REQUEST

Current Zoning: CC, LWPA (commercial center, Lake Wylie Protected Area)
Proposed Zoning: CC SPA, LWPA (commercial center site plan amendment, Lake Wylie Protected Area)

Approximately 26.59 acres located in the southeastern corner of the intersection of Rhyne Road and Mount Holly Road.

The petition proposes to amend petition 2008-125 to allow the development of up to 336 apartments on vacant land.

RZ-1.0

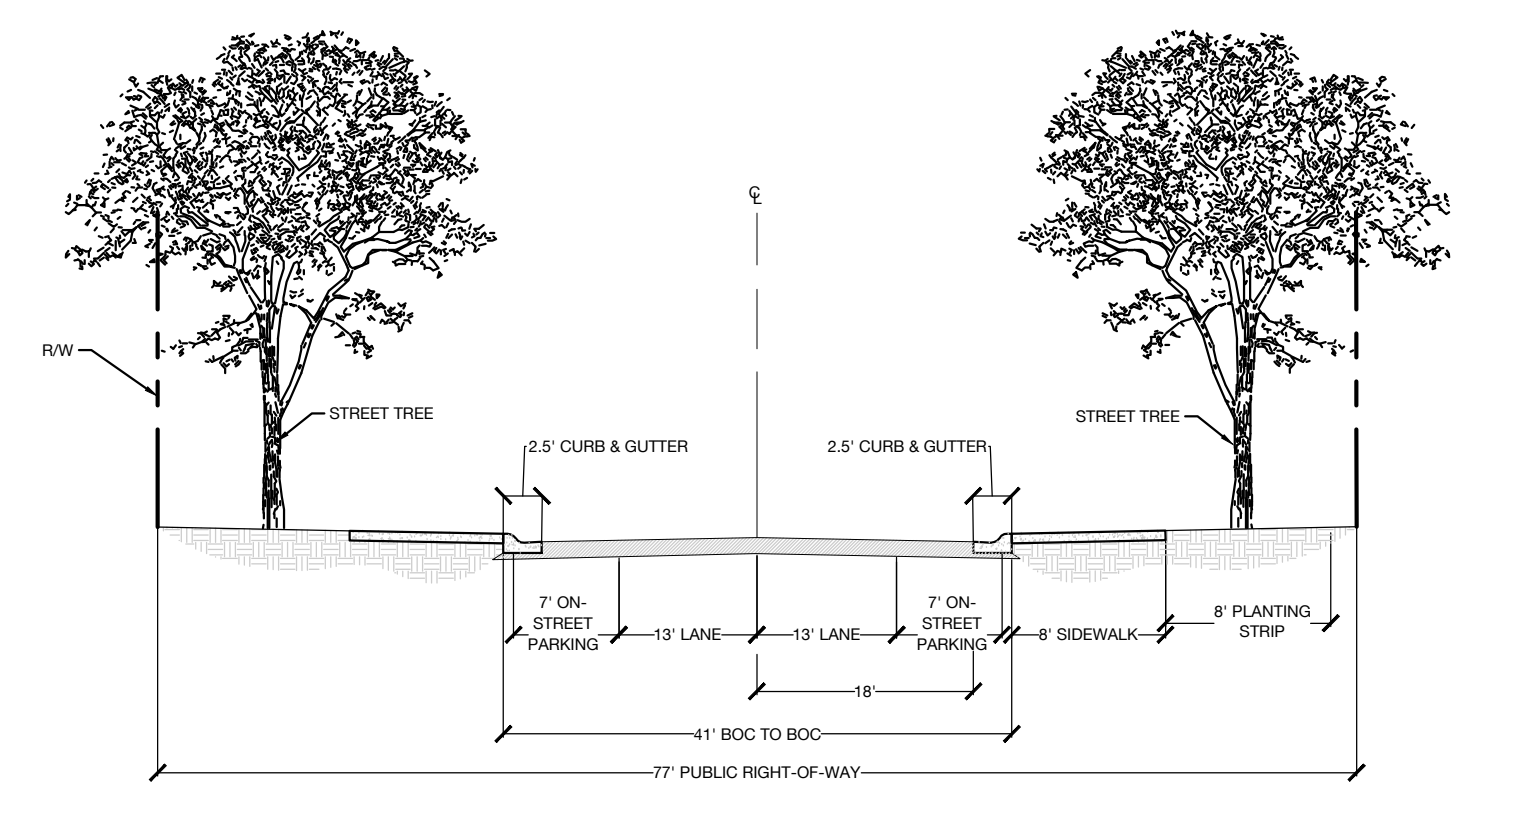
1. Revise building locations to be in compliance with setbacks as stated in Section 9.303(19)(e).
2. Revise building orientation to limit the number of side facing buildings as they relate to the Public Road 1.
